SITE INSPECTION RECORD

WR : 3415845	Site : 10 Barrie Crescent , Bodmin PL31 1BN	Date: 19/05/2021
Inspector : Steve Bampton		Coordinator Name : Stephanie Dinwiddy
Scheme Type : Small build		Inspection Type : Pre start meeting
Scheme Type 2 : --		Inspection Type 2 : --
Scheme Type 3 : --		Inspection Type 3 : --
MH or Pipe Run	Comments	Photo
Other Asset	Offer letter Please send out offer letter scheme is suitable for small build	
Other Asset	Small build required New plot requires diversion of 100mm Pitch Fibre sewer to ensure 3m easement, currently public sewer is approx 500mm from planned footing. Diversion as per basic sketch. All work must be in developers land. New inspection chamber required next to boundary wall with number 11 and IC's required to change direction or gradient. Bends must be immediately outside of IC's. Connect back to existing manhole removing all pitch fibre from manhole and rebench as necessary. Existing sewer from manhole will need build close to approval from project coordinator as footing will be 500mm from this pitch fibre sewer.

Block Plan as Proposed
1 : 200

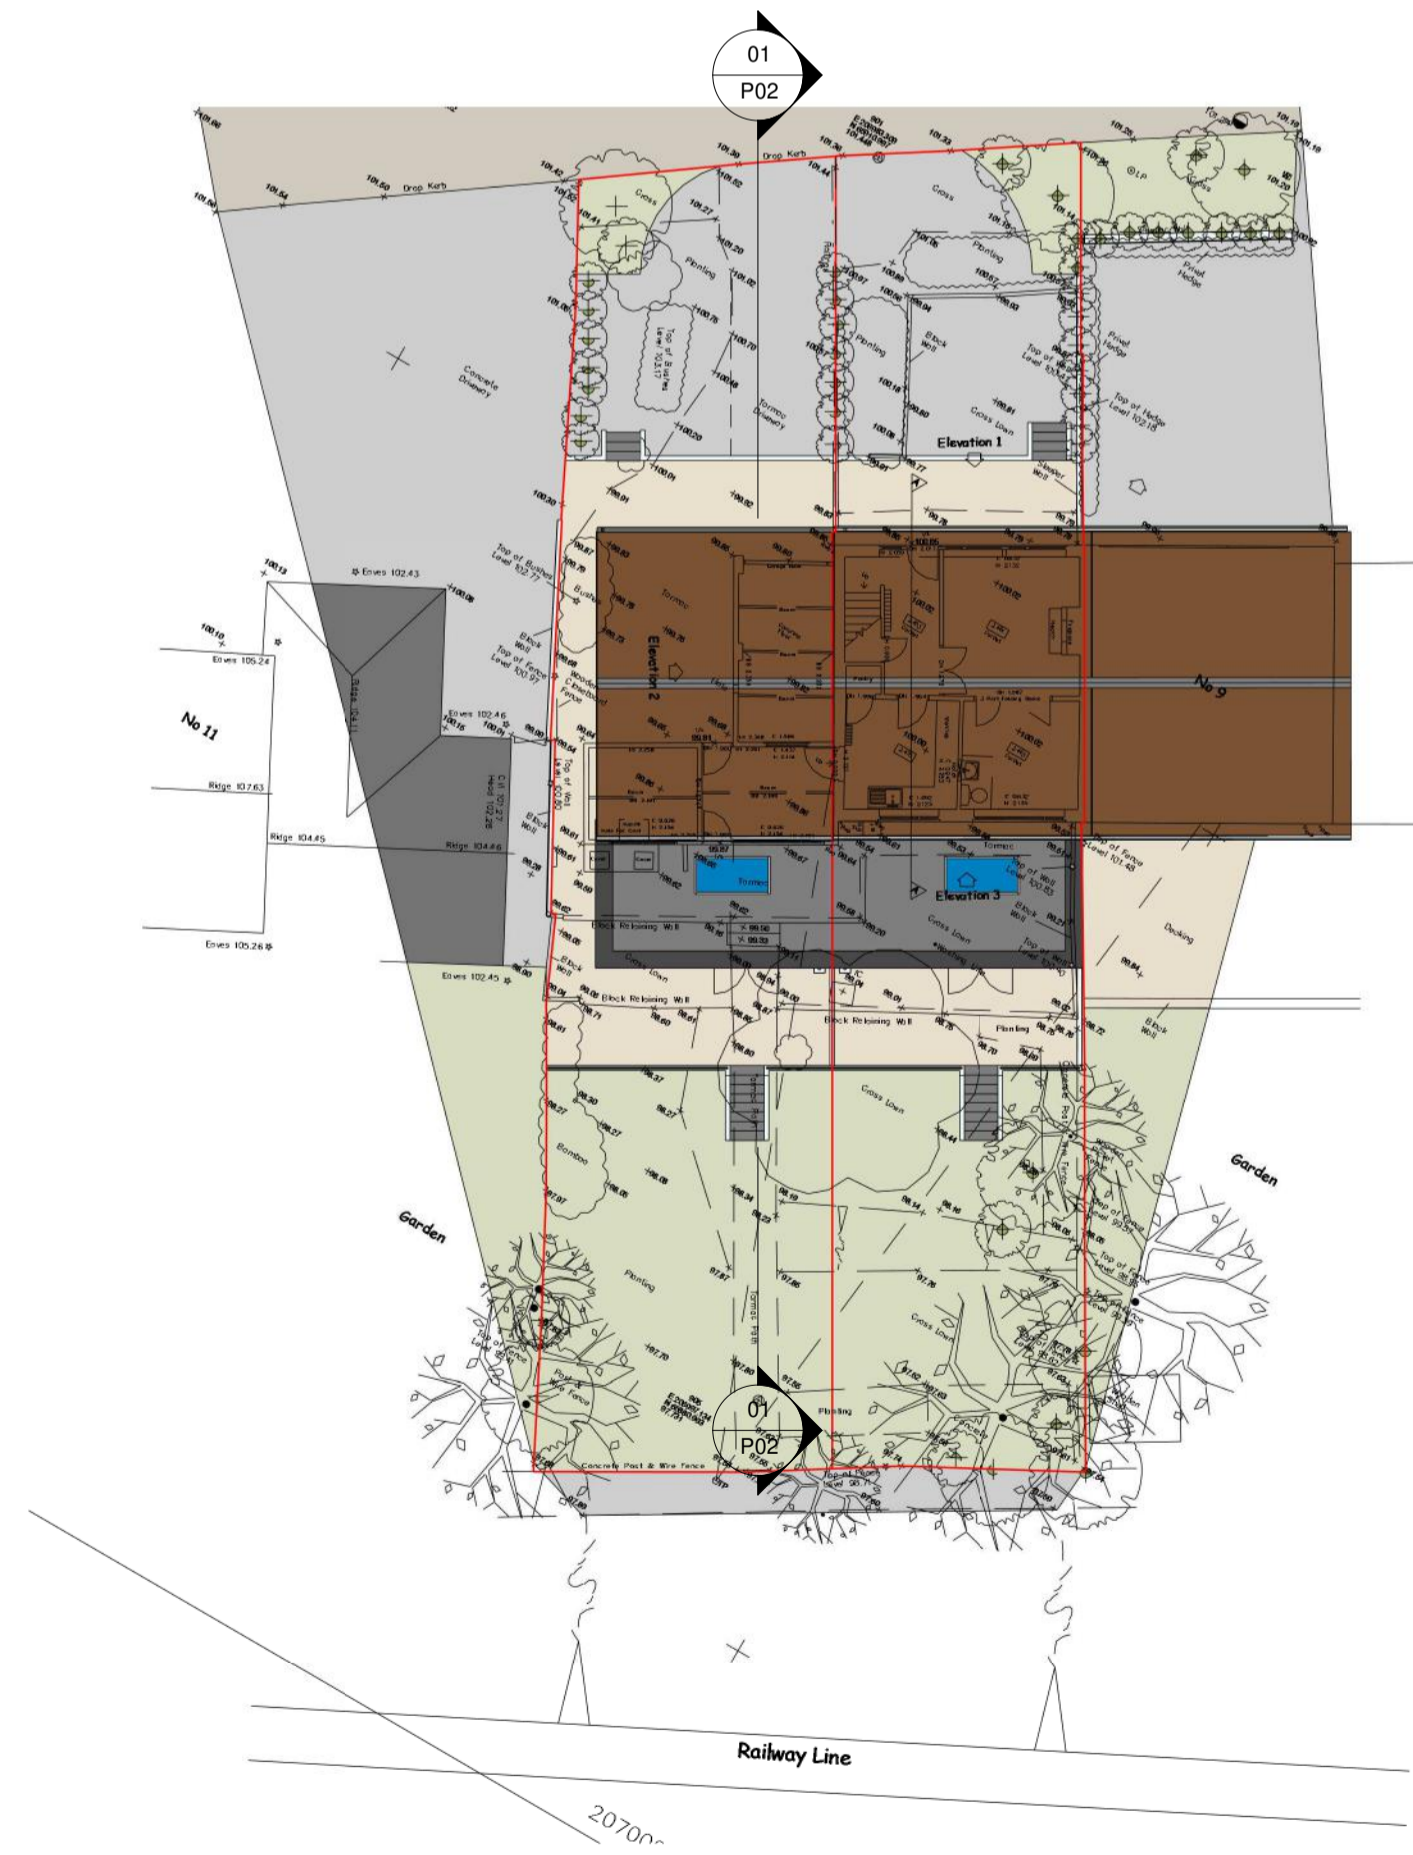
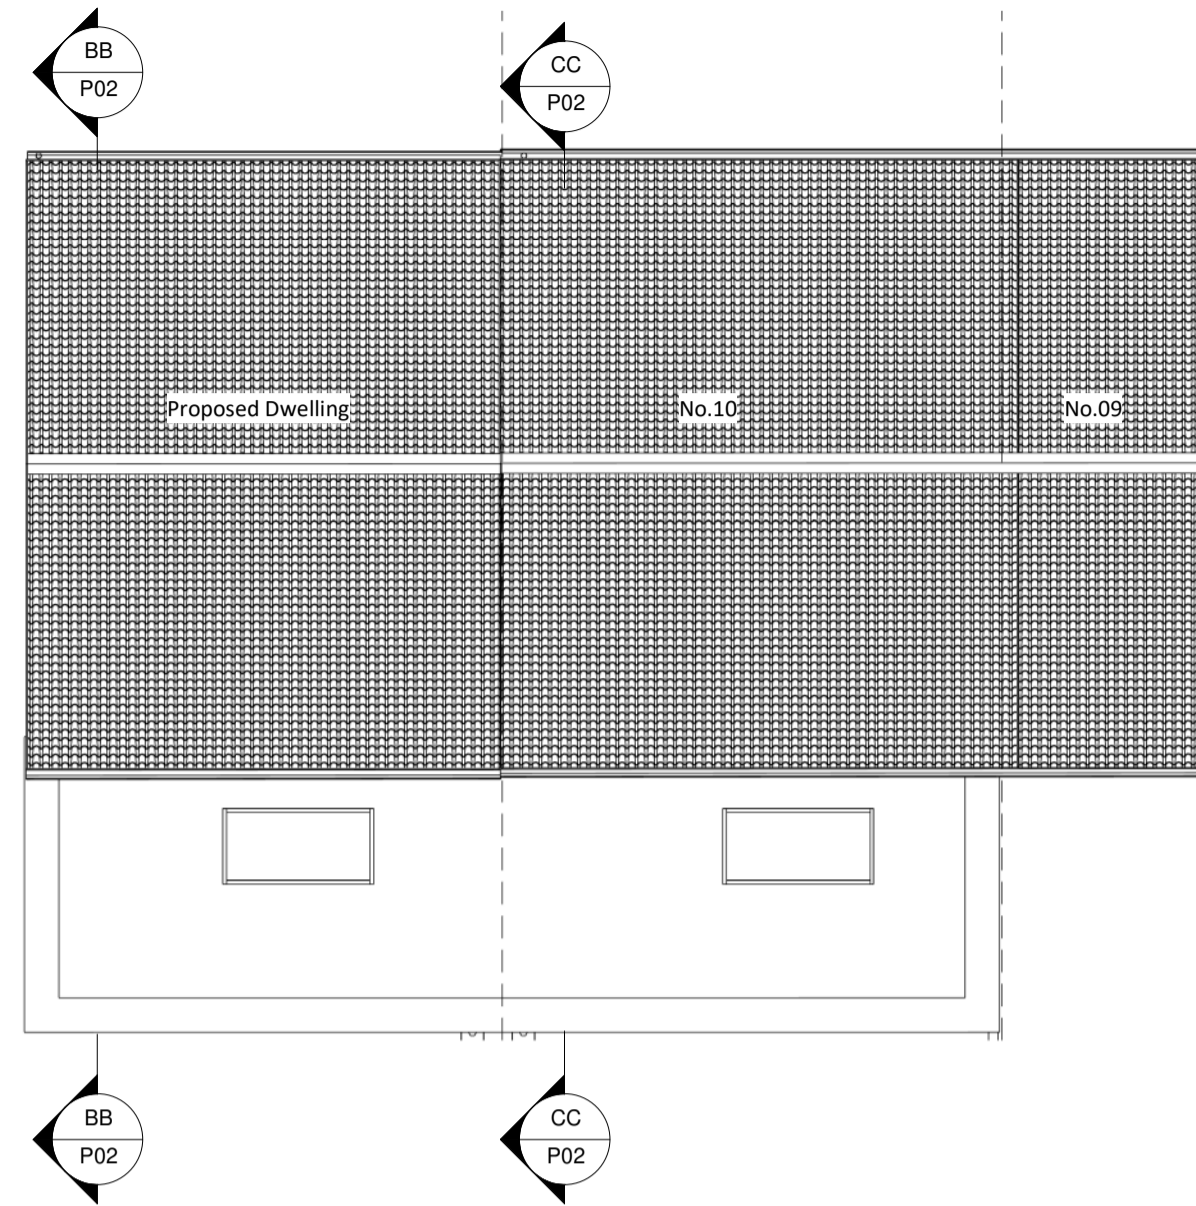
Other Asset	Alternative for developer Diversion could be extended to replace the pipe adjacent to number 10 also, the diversion would rejoin the pitch fibre at boundary wall with number 9. This would upgrade the sewer to 100mm PVC for both props and enable all private drainage to be rerouted to any of the new inspection chambers.	
Pipe	Old diverted pitch fibre pipe This must be removed from the ground and disposed of in the correct manner for sign off	
Other Asset	RAMS payment and offer letter Discussed with Sandra, all must be accepted by Project coordinator prior to any work on the sewer.	
Other Asset	CCTV survey Developer to arrange a CCTV survey of the new pipework before backfill, inspector to be notified when this will be carried out	
Other Asset	Upstream props Developer to liaise with neighbours to manage upstream flows
